**From:**  
**To:** [Planning Portal](#)  
**Cc:**  
**Subject:** Comments on Planning Application 2023/62/91491/W Prickleden Mills, Woodhead Road, Holmfirth, HD9 2JU  
- 61 apartments, age restricted (>55yrs) in 5 blocks  
**Date:** 21 July 2023 17:01:05

I am writing to make comments on behalf of River Holme Connections regarding the Planning Application:

**Application number**  
**2023/62/91491/W**  
**Last updated**  
**17 July 2023**  
**Applicant**  
**Eliston Homes**  
**Location**  
**Prickleden Mills, Woodhead Road, Holmfirth, HD9 2JU**

PROPOSED SITE PLAN

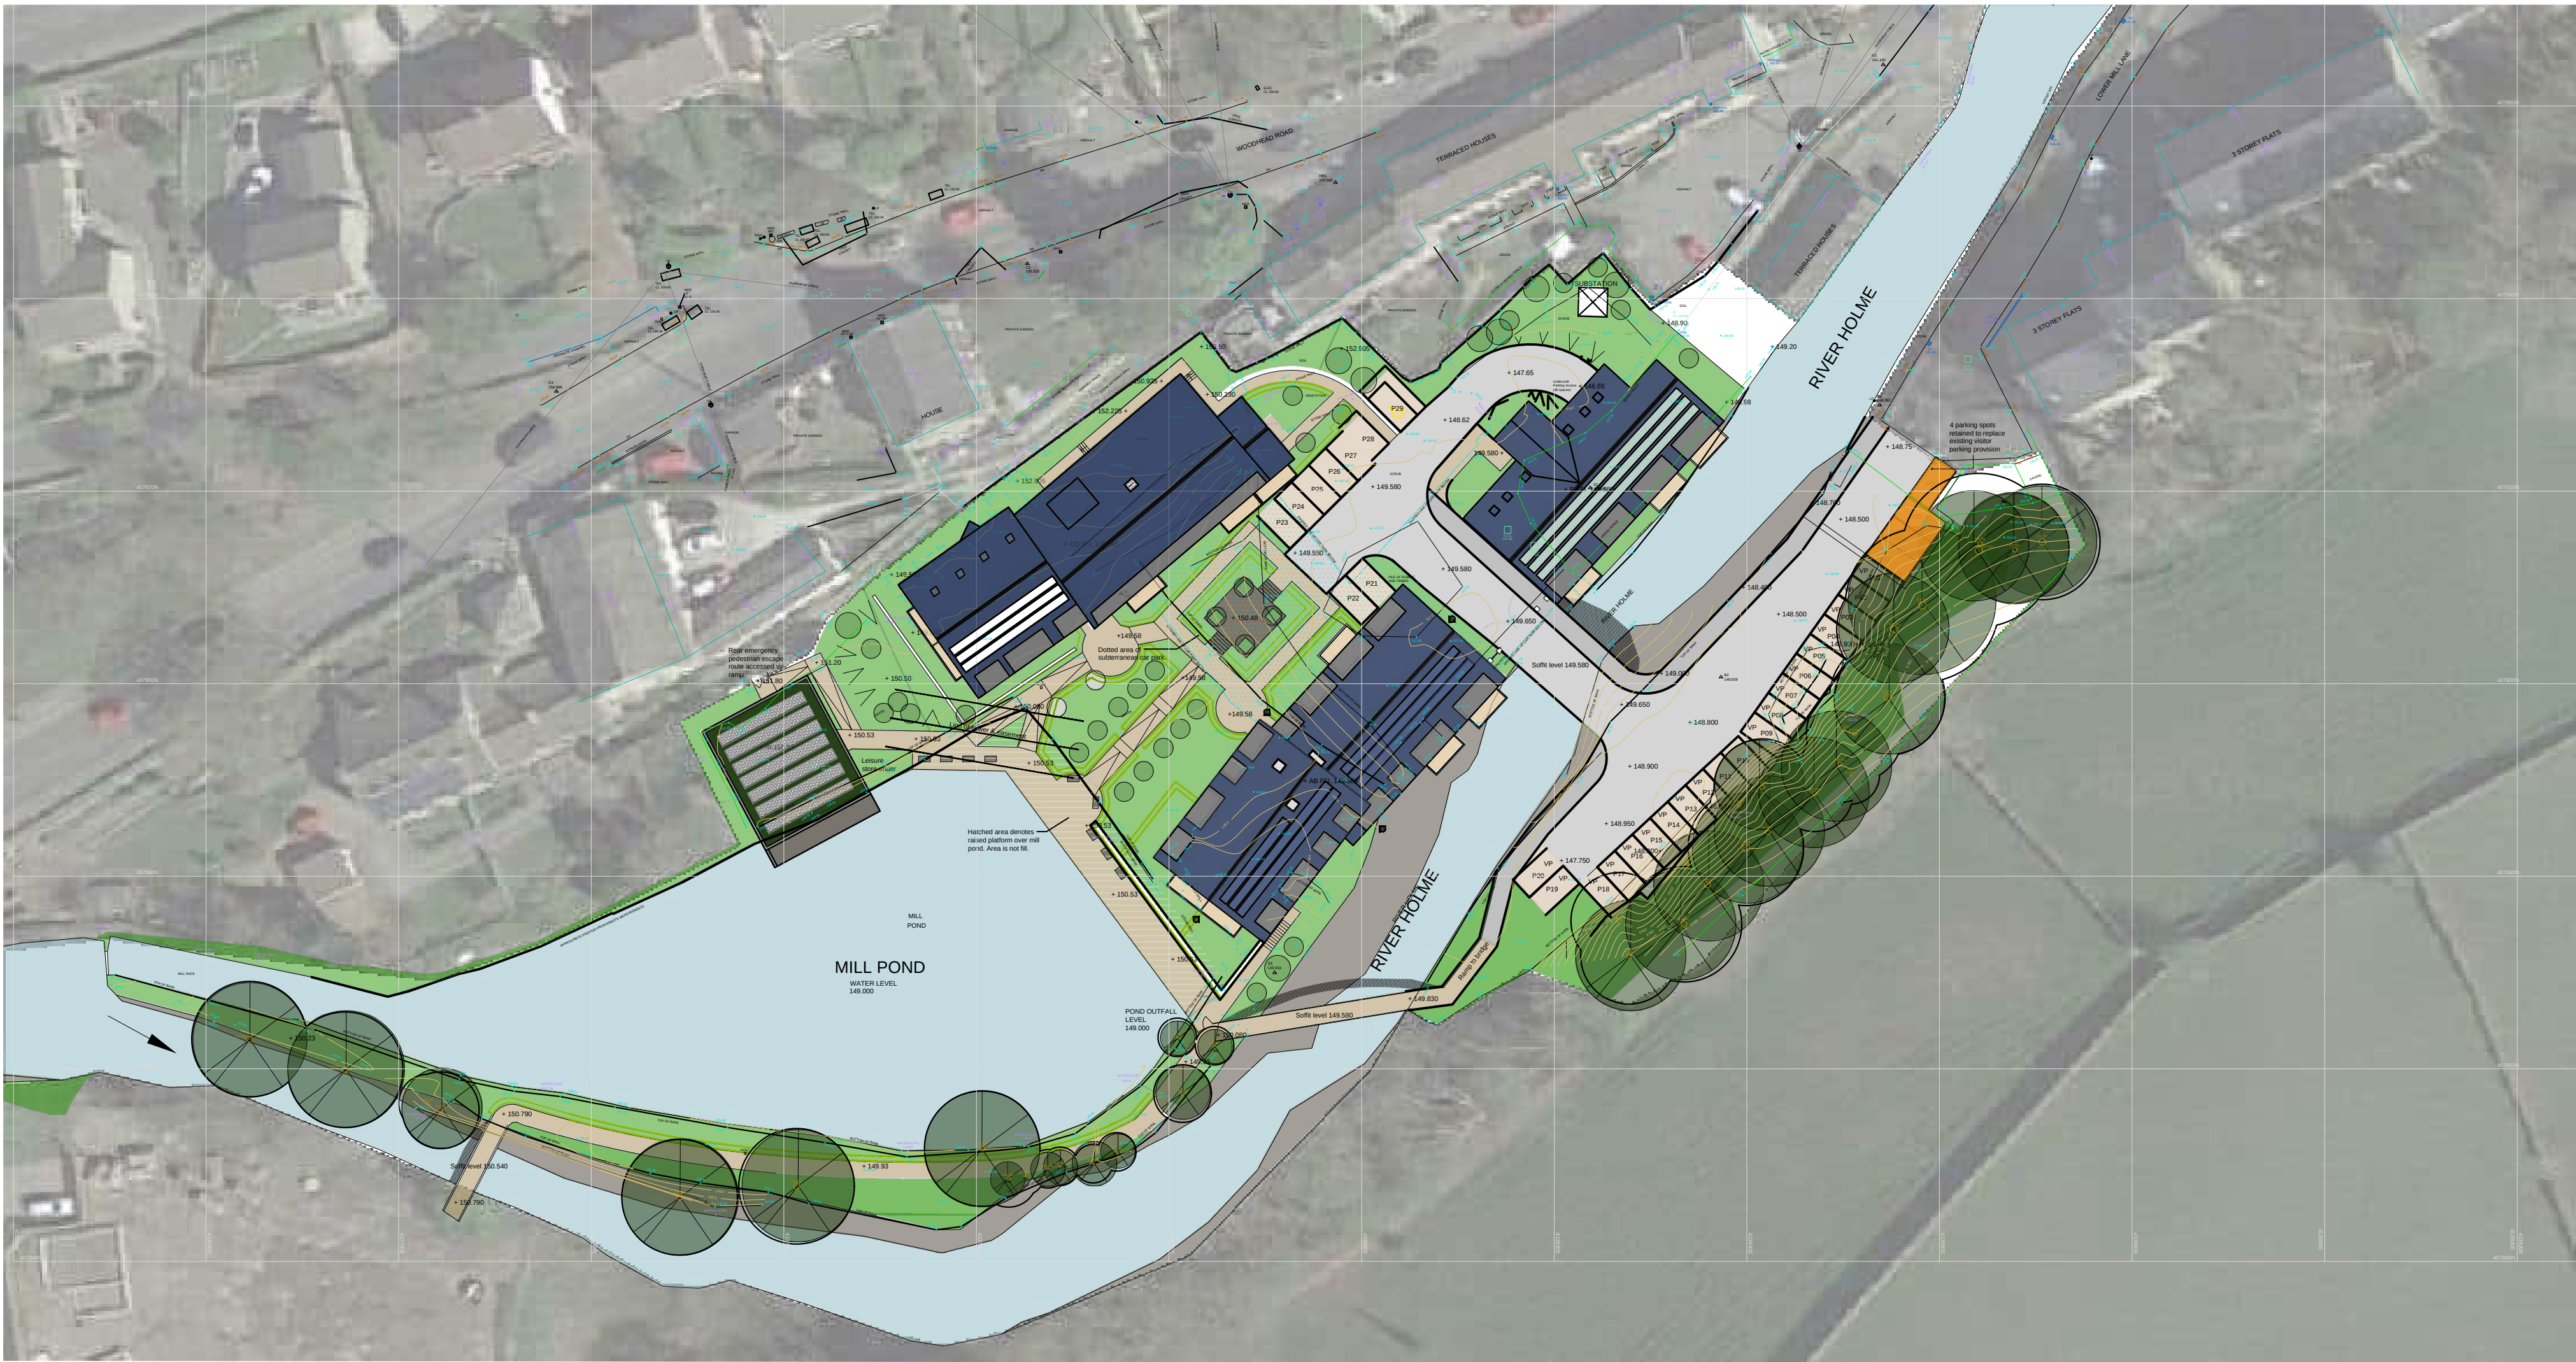
- The proposed pedestrian bridges are too narrow at 1.8 metres. This does not allow adequate space for people passing both ways, wheelchairs, pushchairs or wheeling bicycles. Public access should be recognised as a bridleway to allow cycles. The Riverside Way is a safe route for active travel and the width of the route and bridges should be designed accordingly.

- Again in Connectivity, page 6, there is a comment that Holmfirth centre is “some 300 metres walk from the entrance to the site” and that occupancy will be expected to be from people from the local area. If this is the case, then it is not sustainable to provide 78 car parking spaces. This could be halved, and thereby increase green community space, and prevent “dirty run off” from parking bays right on the edge of the river. Surely many people wanting to purchase will be looking to dispose of their cars and make alternative arrangements, such as car hire?
